From: Thomas Callaway
Sent: 25 June 2015 16:17
To: Planning.Responses
Subject: RE: Please find attached amendment on planning application Ref: M/43/15/PL

APPLICATION M/43/15/PL
NO:

Registered: 18-MAY-15
Site Address: 6 Alleyne Way Elmer Middleton-on-Sea PO22 6JZ

Description of Works: Demolition of existing bungalow, detached garage & greenhouse & erection of 1 No dwelling, garage & garden shed (resubmission following M/24/14/PL).

Title			
Drainage Layout			
Scale 1:200		At original A4	© Robert Clark Associates Ltd
Drawing Number 1556/D1.1			Revision -

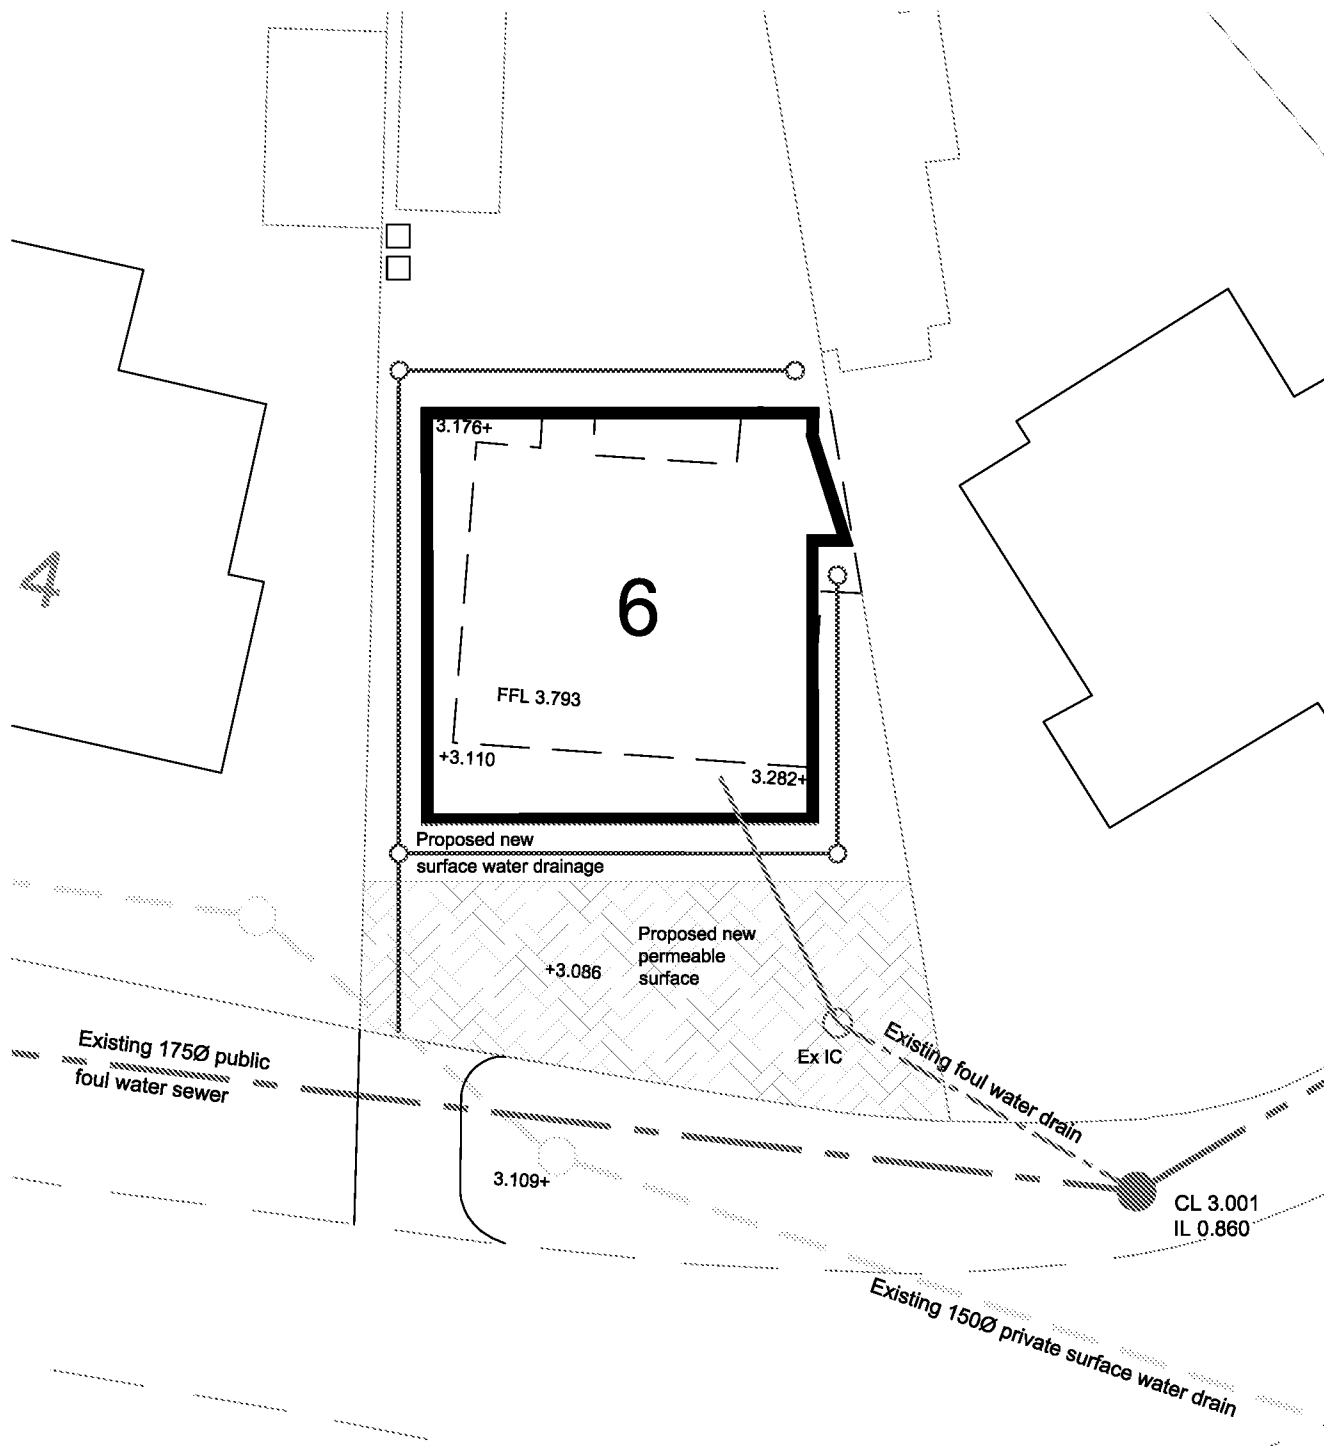
The applicant is proposing to discharge roof water to the private surface water system, as agreed by Elmer Sands Estate due to proximity to the sea outfall. The driveway is to be a self draining permeable paved area.

I would suggest that the roof drainage is linked into the permeable paving with a high level overflow to the private system would offer better attenuation and reduce the rate of discharge, as long as the permeable paving was not at risk of overflowing itself.
